Erection of 1 No. two-bedroomed detached bungalow. This application is a Departure from the Development Plan.

Land adjacent to Pindars Lyminster Road Lyminster

Thank you for your internet representation made on 2nd April 2018 which has been recorded as '**an objection**' with the comments as follows:

DRAWING PROPOSED SITE PLAN DATE: JANUARY 2018 DRAWN: T. Murray	SCALE 1/500
DRAWING: 18/04/4	REVISION:

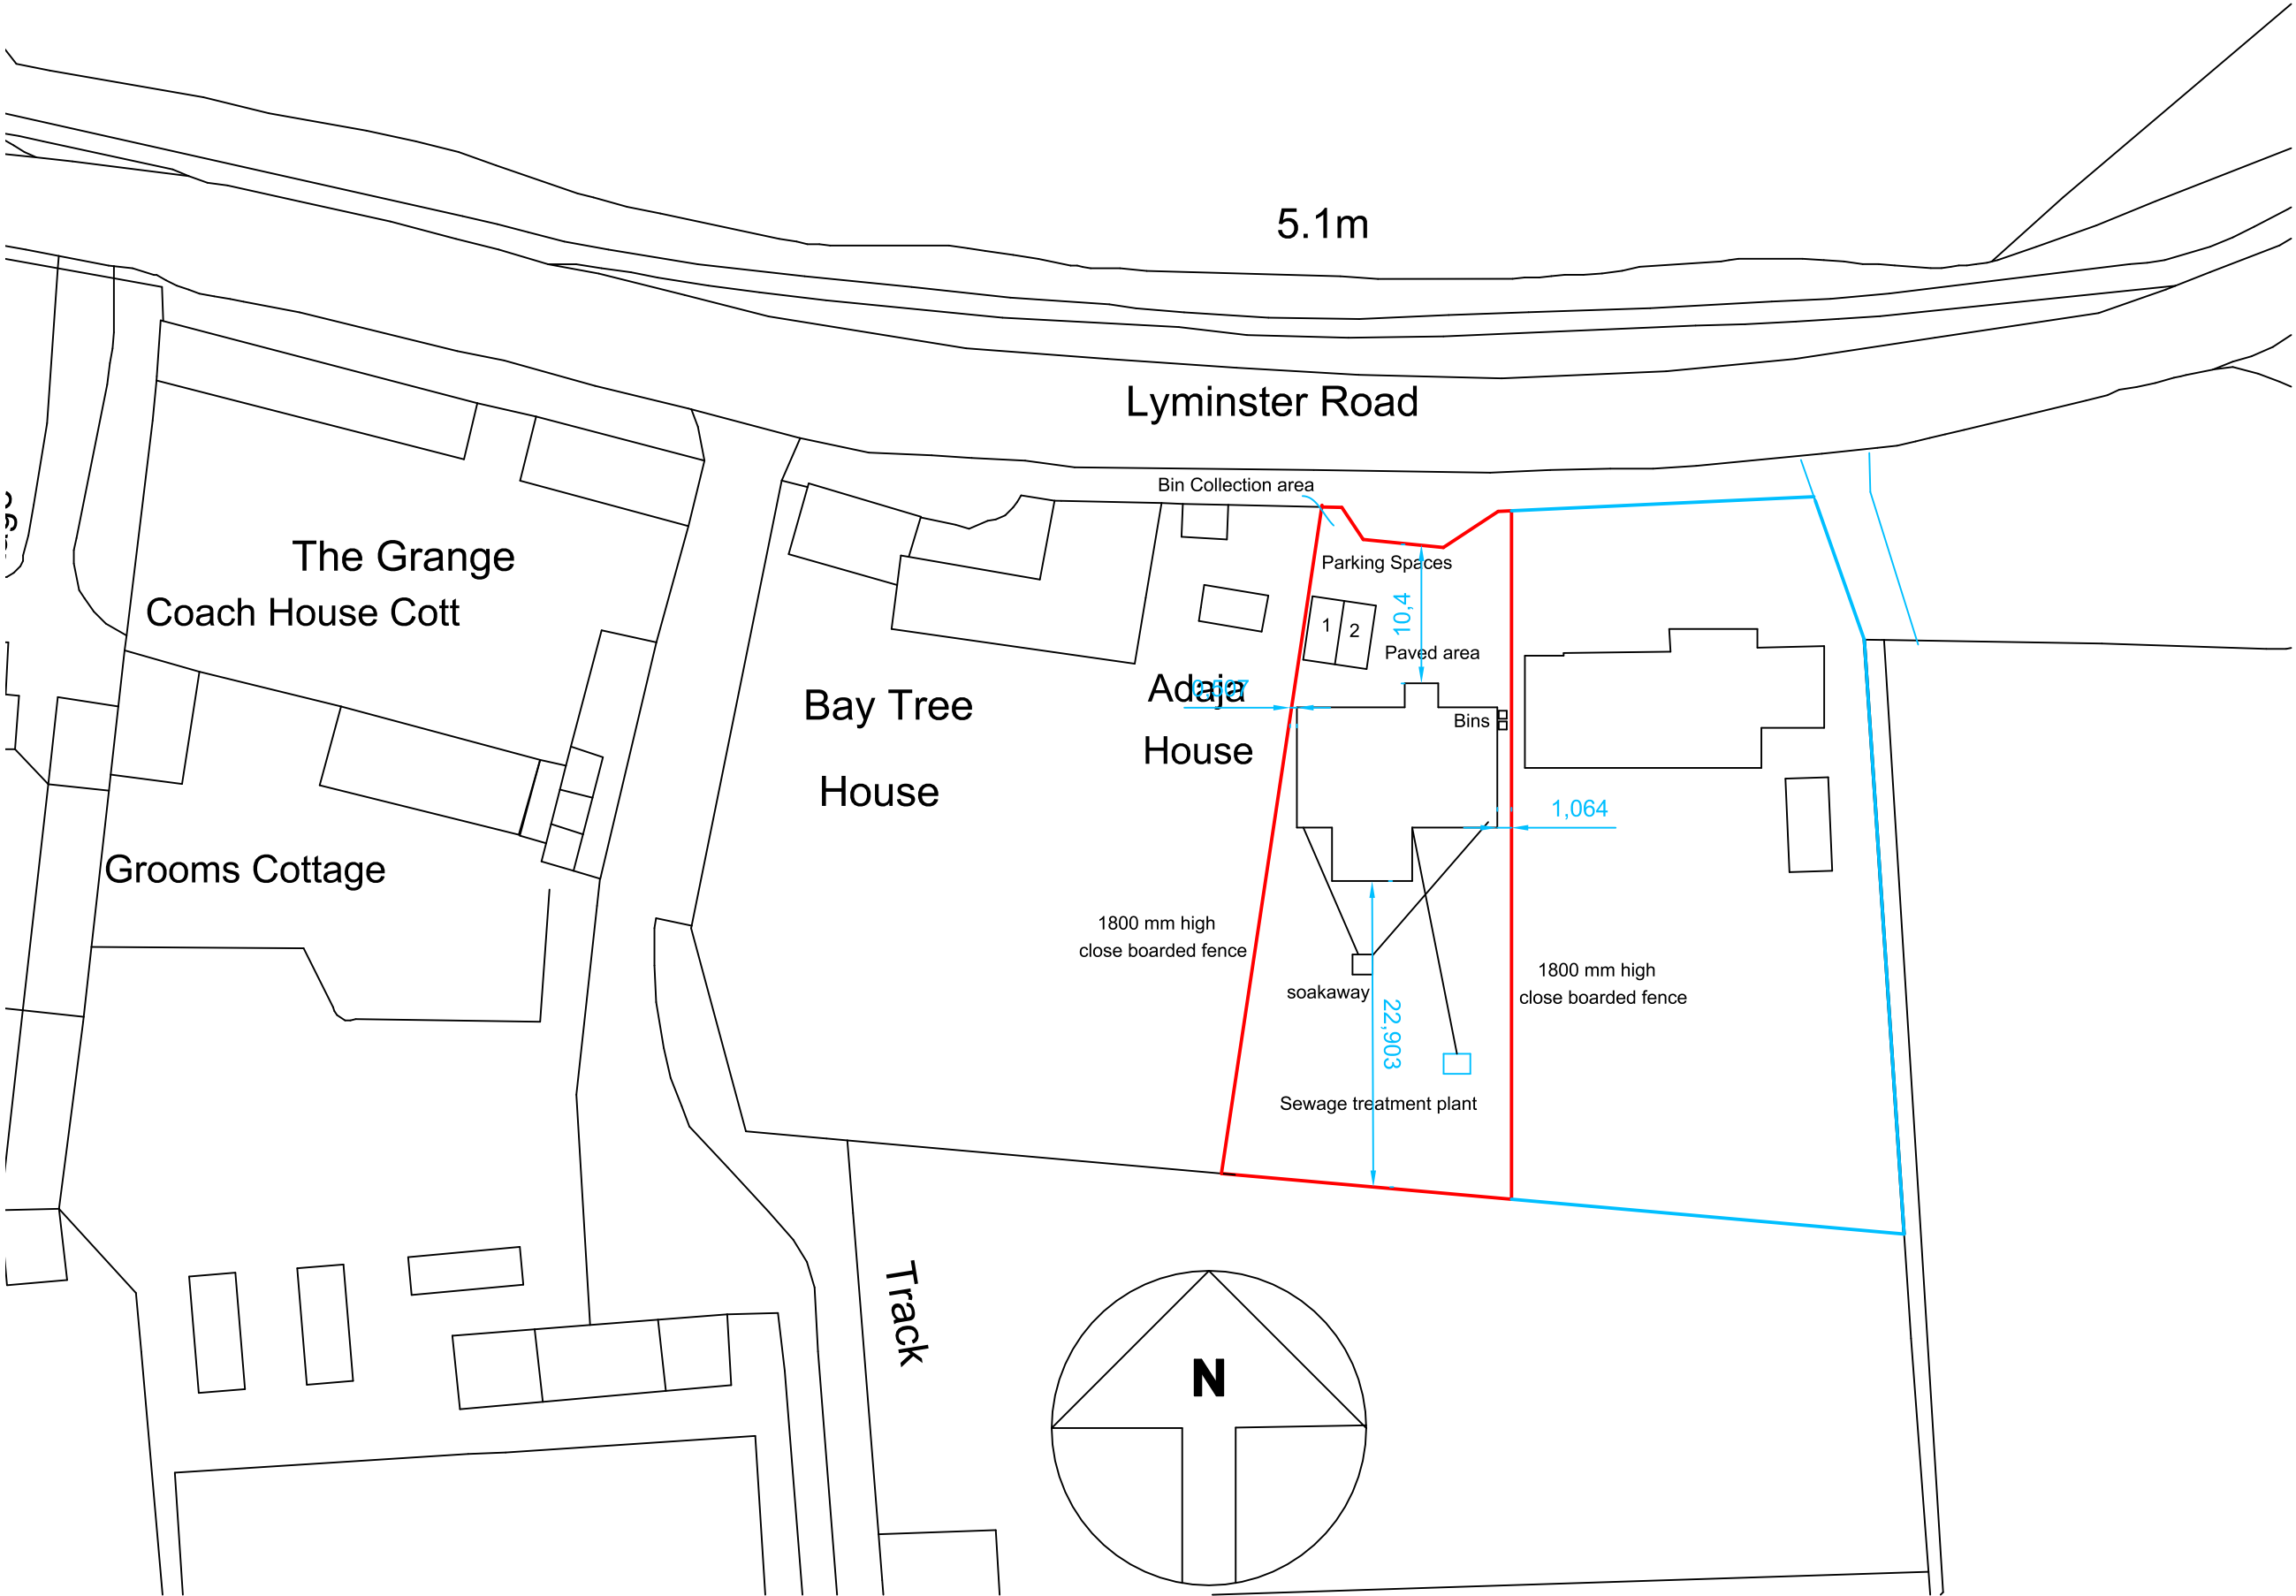
The plans for the West boundary show the holly hedge being removed and replaced by a close- boarded fence. When we built Pindars 50 years ago we were clearly aware that the west boundary belonged to Mr FN Dickins then owner of Bay Tree House, and has remained so ever since.

We would also like to draw attention to the fact that a mature hedge is a valuable asset to the local wildlife, and large numbers of small birds nest in the holly every year, especially as much of their habitat has now been destroyed.
